Our ref: **INVALID APPLICATION ACKNOWLEDGEMENT**
GCC Application Ref: **21/02538/FUL**

SITE: 1009 Argyle Street Glasgow G3 8LZ

PROPOSAL: Frontage alterations and installation of vent to rear.

ADDITIONAL INFORMATION REQUIRED FOR APPLICATION 21/02538/FUL

DRAWING TITLE
LOCATION & BLOCK PLAN

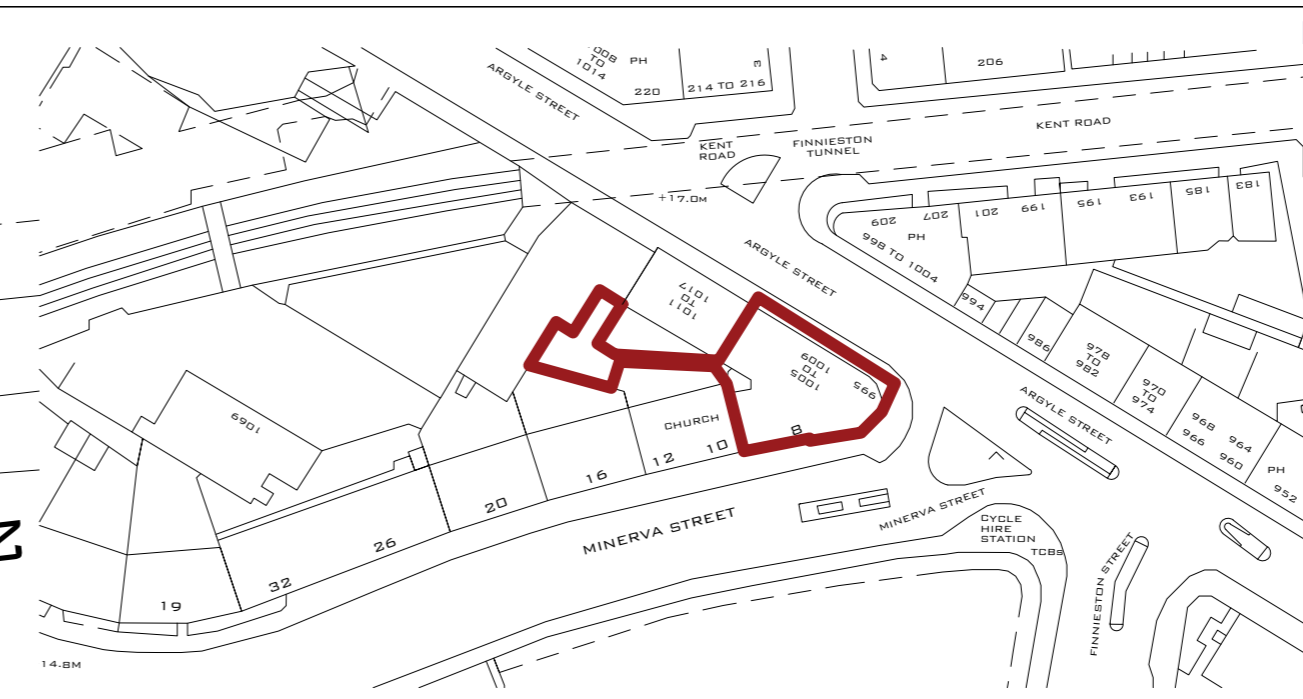
001 Please provide a scaled plan not less than 1:1250 scale, that is sufficient to identify the land to which it relates. The application site must be outlined with a red line and any adjoining land within the control of the applicant must be outlined with a blue line. Where applicable the location plan must demonstrate the connection to a highway within the red line boundary.

The location plan submitted is for a different job hence request for location plan.
